Town & Country Planning Act 1990 (as amended)
Town & Country Planning (Development Management Procedure) (England) Order 2015 - Article 5

Application No: AL/39/22/OUT
Site Address: Land to South of Dukes Road Fontwell Arundel BN18 0SP
Description of works: Outline application with some matters reserved (appearance, landscape and scale) for the erection 9 No. residential dwellings. This application is a Departure from the Development Plan.

Thank you for your internet representation made on 5th May 2022 which has been recorded as an objection with the comments as follows:

1 Proposed Street Scene
Scale: 1:200

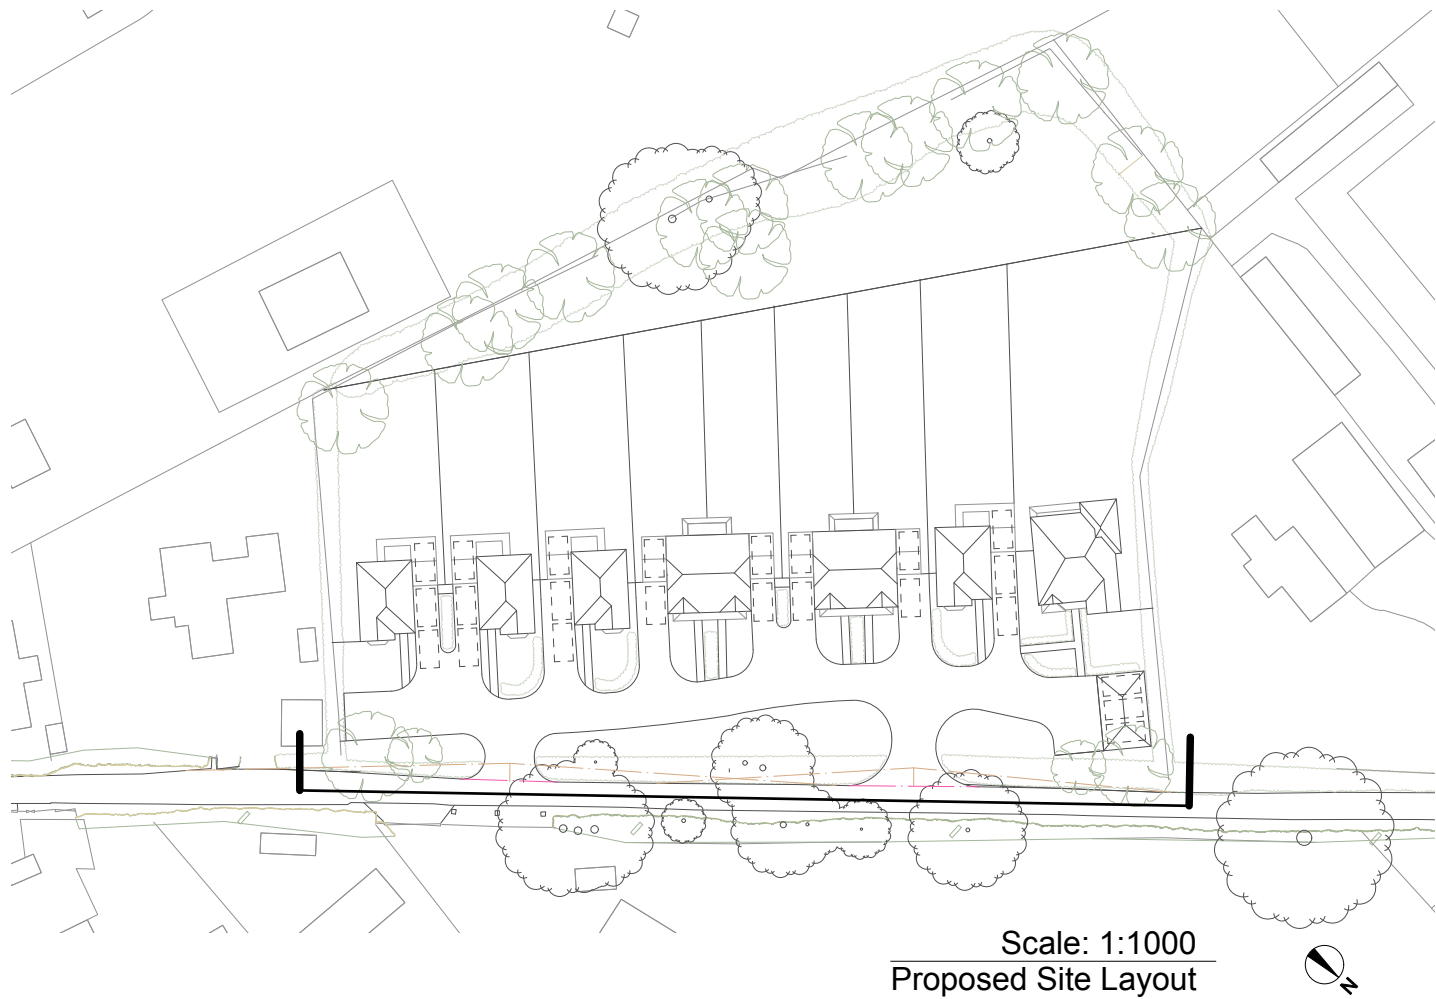
Dukes Road is an unclassified rural road, and lies outside of the built up area. At present the nearest dwelling to my property is approximately 50m away, but the proposed development would bring Plot 1 within 20 metres of my house, and up to my fence boundary. Only Plot 4 would be the same, ie 50 metres away, so the whole development will bring an unacceptable loss of privacy. Under Policy D DM1, 3- Impact - the council state that "new housing must have minimal impact to users and occupiers of nearby property and land. For example, by avoiding significant loss of sunlight, privacy and outlook and unacceptable noise and disturbance". Building nine houses in this location will bring significant lack of privacy and noise to what is a quiet country lane. The street scene illustrates that the development visually would not be in keeping with the area, Policy D DM1 2 states that 2. Appearance/attractiveness- "applicants must demonstrate a high standard of architectural principles, use of building materials, craftsmanship and hard and soft landscaping to reflect the local area" This row of modern houses will in no way reflect the local area or blend in with the rural landscape. The majority of existing properties are chalet bungalows or bungalows and the artists' impression of the proposed houses clearly demonstrates that the development would certainly not enhance the visual impact; quite the opposite. If permitted, this development will increase the current numbers of dwellings in Dukes Road by almost 40%. There are already limited services in the road in terms of water, electricity and drainage, and there is no mains gas at all- indeed the entire road is dependent on LPG gas. Note that Policy ECC DM1 D- states that "All proposals will need to demonstrate a suitable connection to the electricity distribution network, or appropriate energy storage facility, and provide evidence to demonstrate that the connection will not result in unacceptable impacts upon the landscape, natural and historic environment or visual and residential amenity"
